## MEMORANDUM

**DATE:** February 3, 2016

**RE:** Adams School Redevelopment Phase II a.k.a. 65 Munjoy Street:  
Some Supplemental Comments about Design & Process Problems  
[Rough but Meaningful DRAFT]

DRAWN BY
EAC
 SHEET TITLE
FIRST FLOOR & SITE

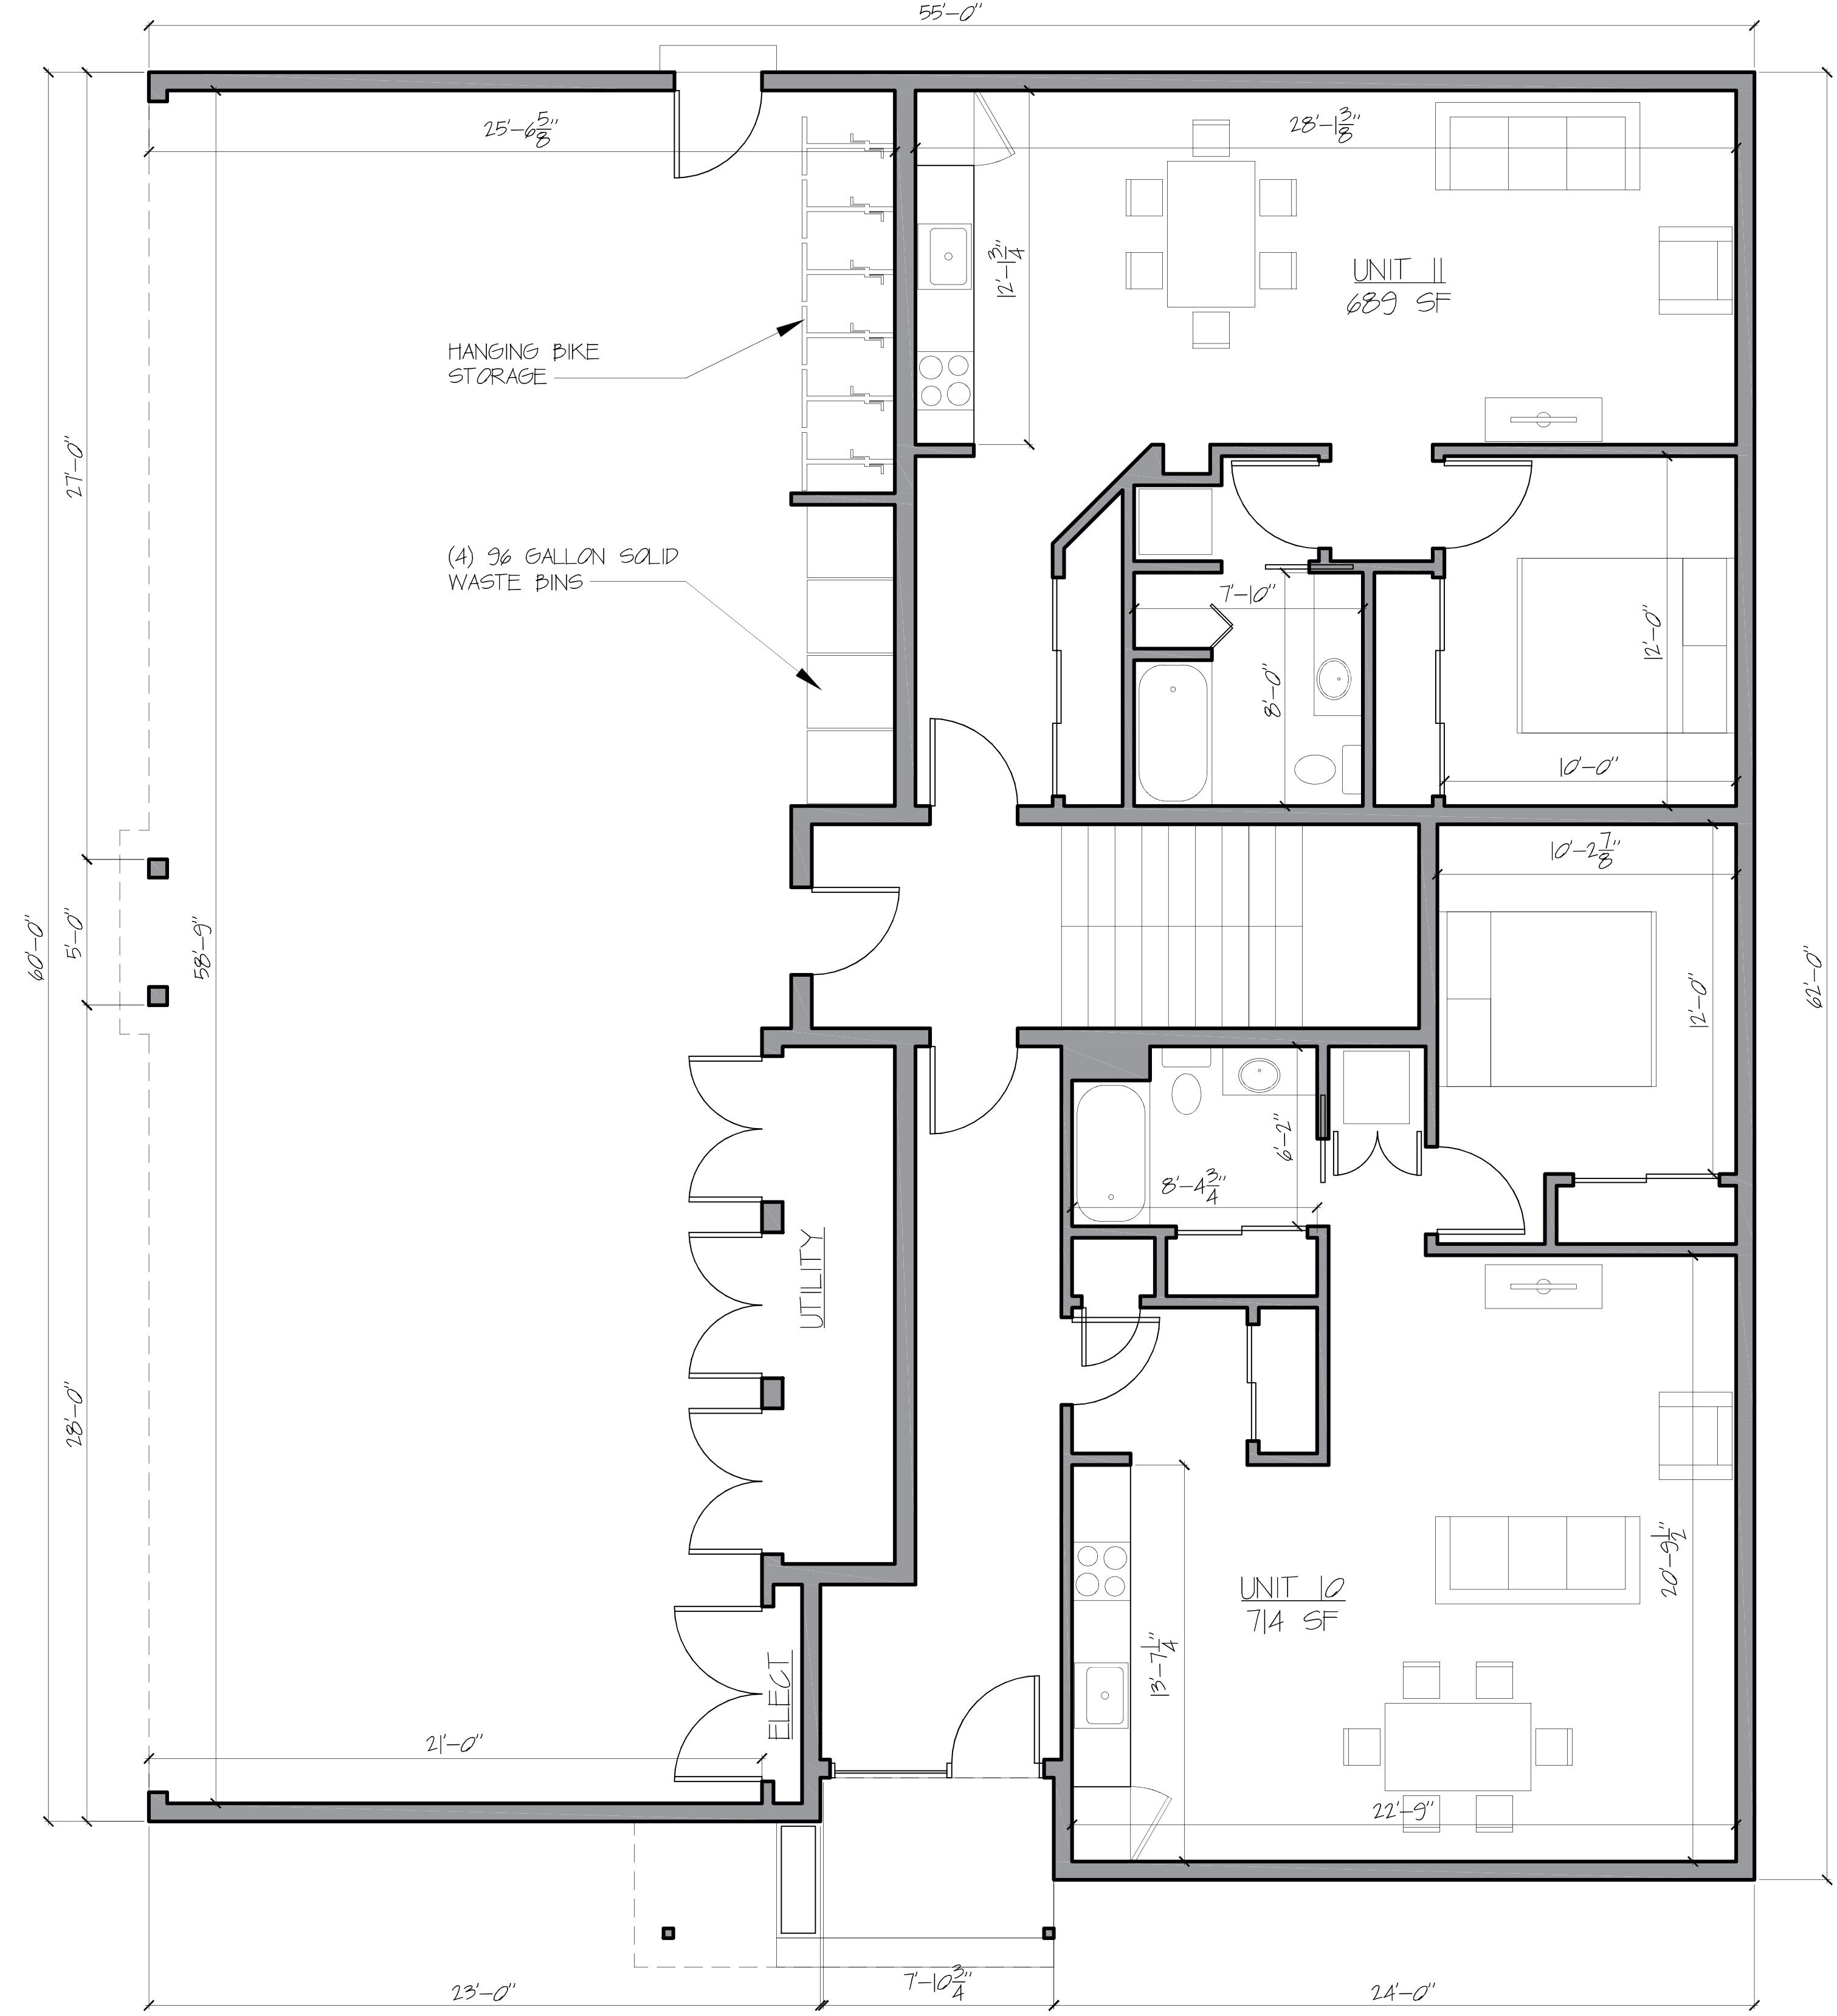
1. **“Big Box” Design (even with “new” bay windows hanging at one end)**
2. **Large and Fairly “Flat” Façades Facing Munjoy St and Park**
3. **Should Look Like a Couple Individual Buildings, with Connector in Middle.**

4. **Poorly Articulated**
5. **Insufficient Reference to Traditional Design Elements & Neighborhood Vernacular**
6. **Design Fail: Designed So You Can Park Your Car in the House!** Sits Too Low to Ground, so Now Designers Want to Install Porthole or Mini Windows in First Floor to Create a Sense of Privacy for First Floor Occupants. Will look ugly!

7. **Porthole or Mini Windows.** See #5 above. Also, all first floor windows facing the street should be full size. Frost the lower panes if necessary for any mini windows on first floor, including the garage, to help address the urge to go “mini.”

8. **Shouldn't Build a 3<sup>rd</sup> Floor So You Can Park Cars in Your House!** Gives the building a bad look at street level, and shades the homes on Moody Street.

1. **Lacks Life**
2. **Lacks Soul**
3. **Represents a Missed Opportunity**
4. **Presents Just a “Sheer Wall” Toward the Park**
5. **Sits Too Low. Shouldn't Be Designed Both Low to Ground -- and High in Air -- to Accommodate Cars**
6. **Small First Floor Windows Look Strange, Make First Floor Look Lifeless**

CONCEPT DOCUMENTS
2ND & 3RD FLOOR

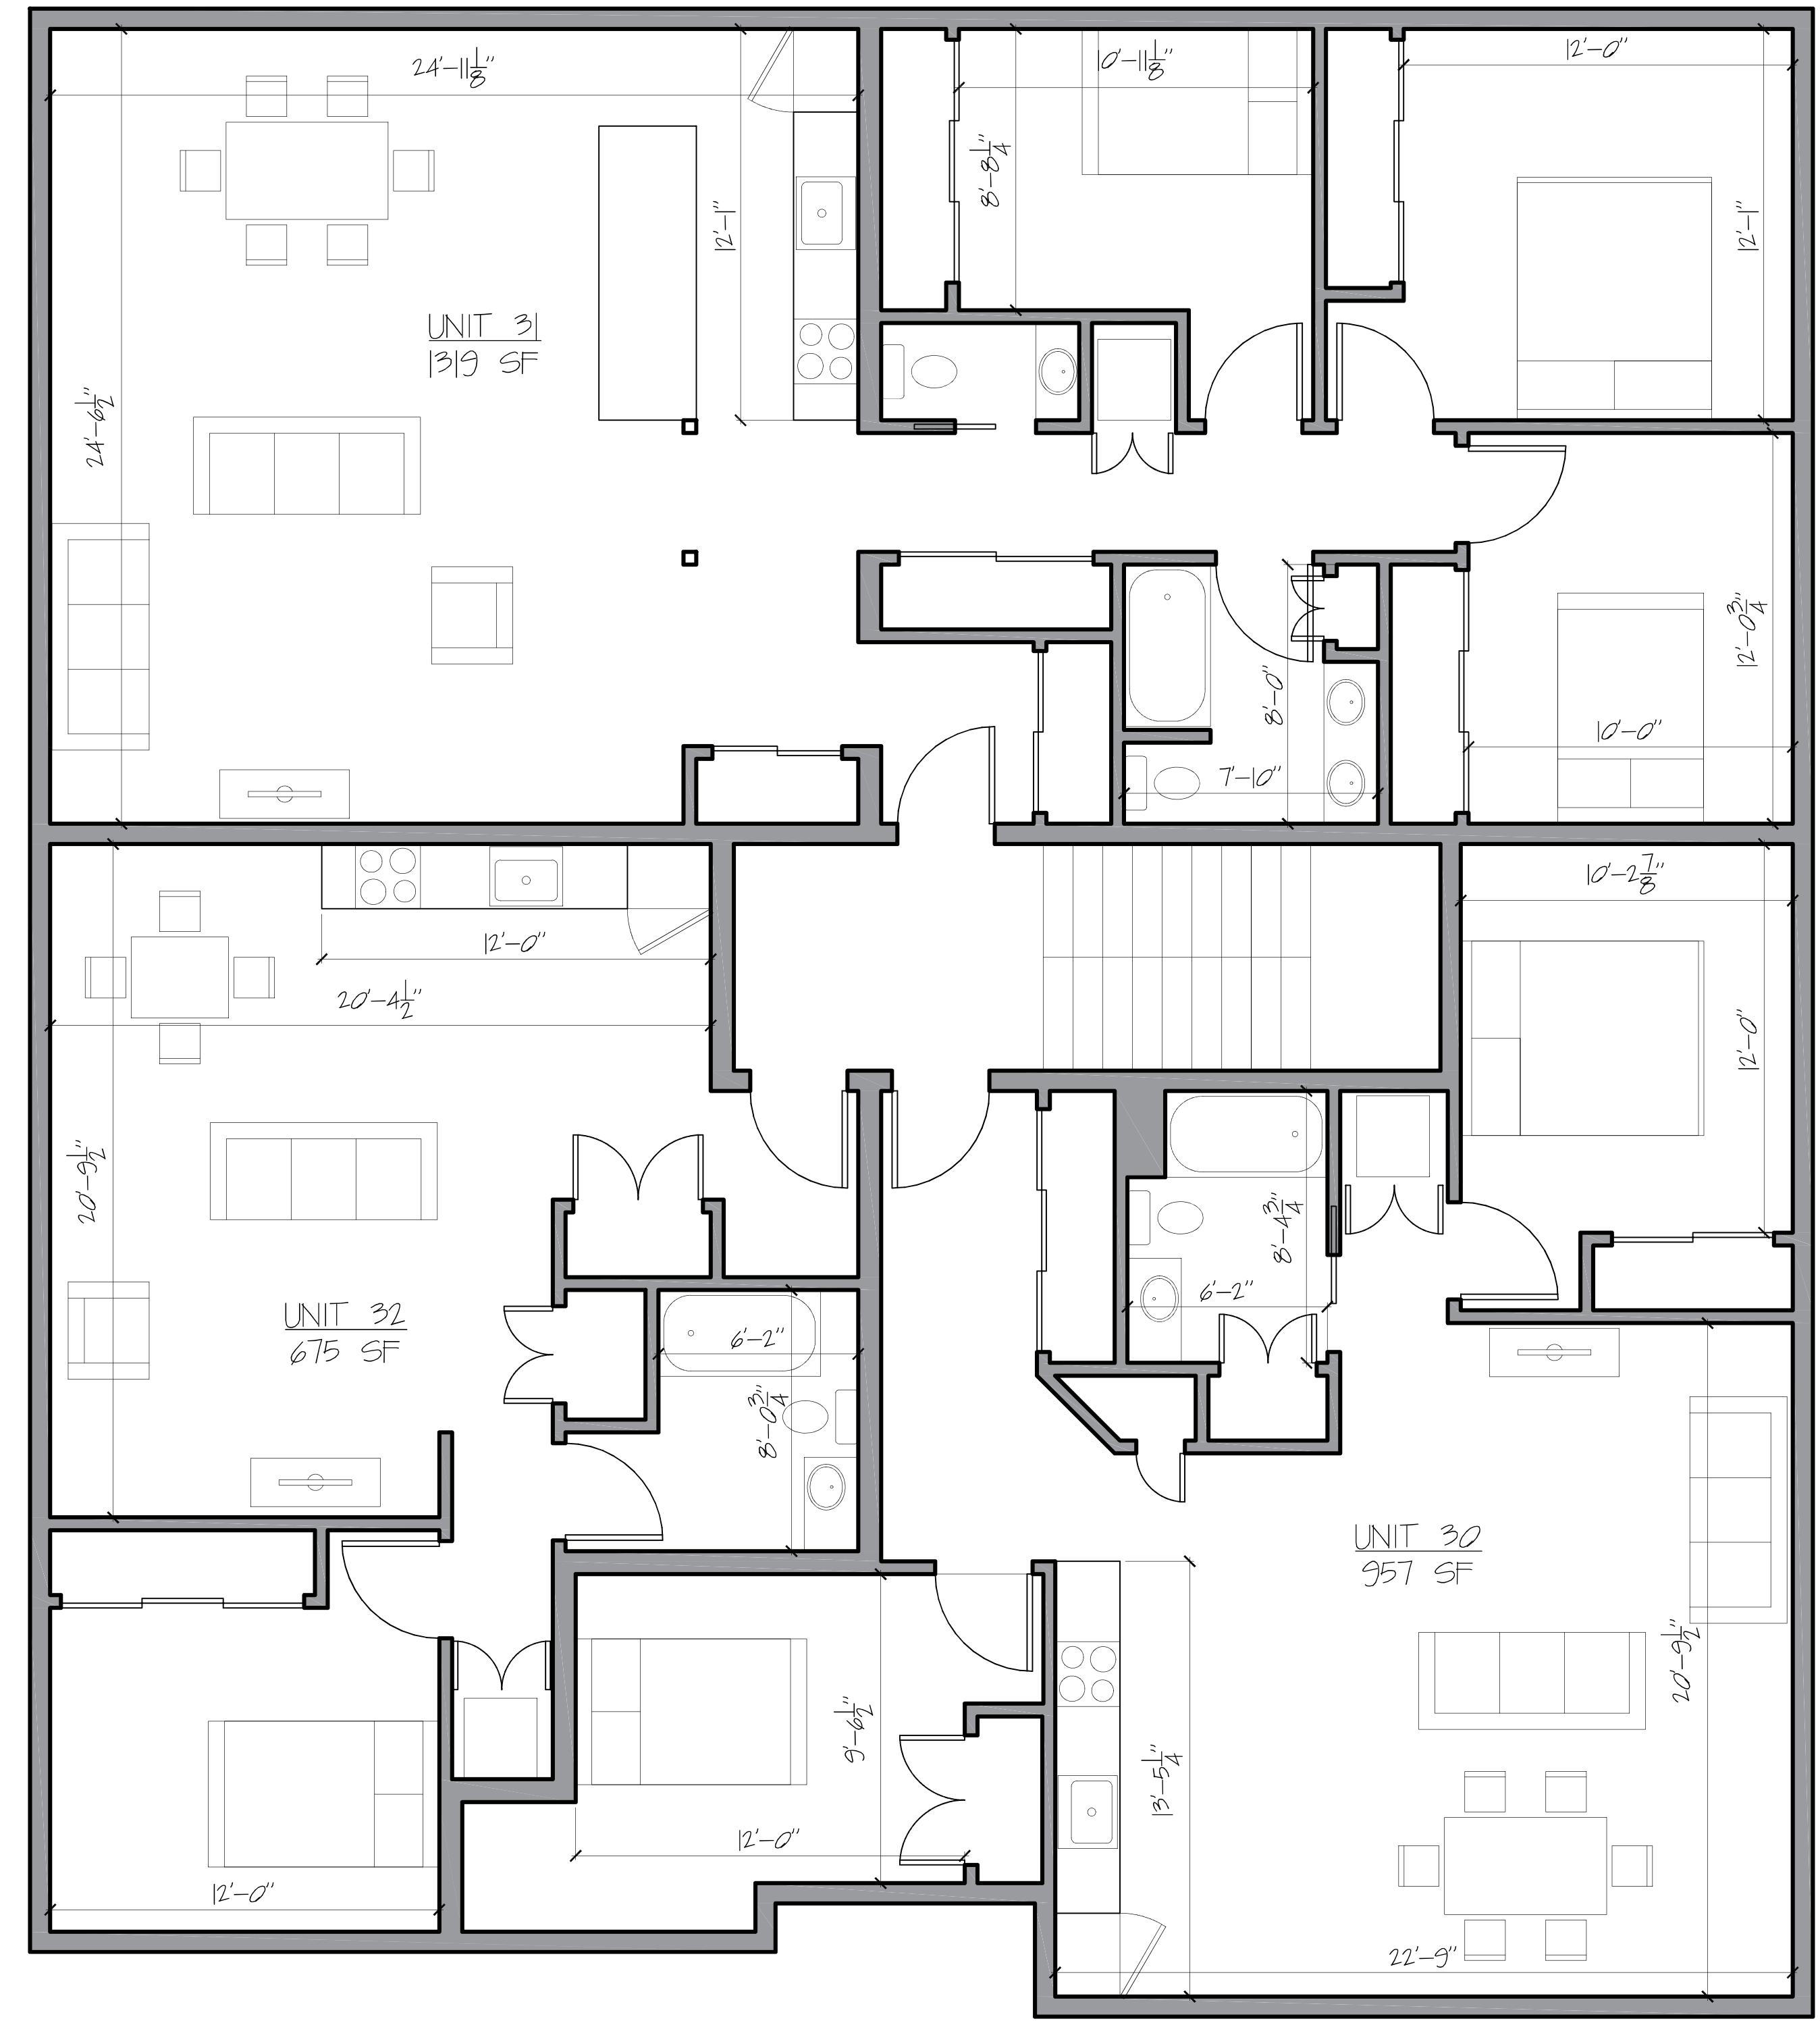
10. **The “Look.”** Should be considering a more traditional look (Bluestone), or a more modern look but with better articulation (Avesta I). What you have right now is neither, it looks like just a cheap, low-budget big box.
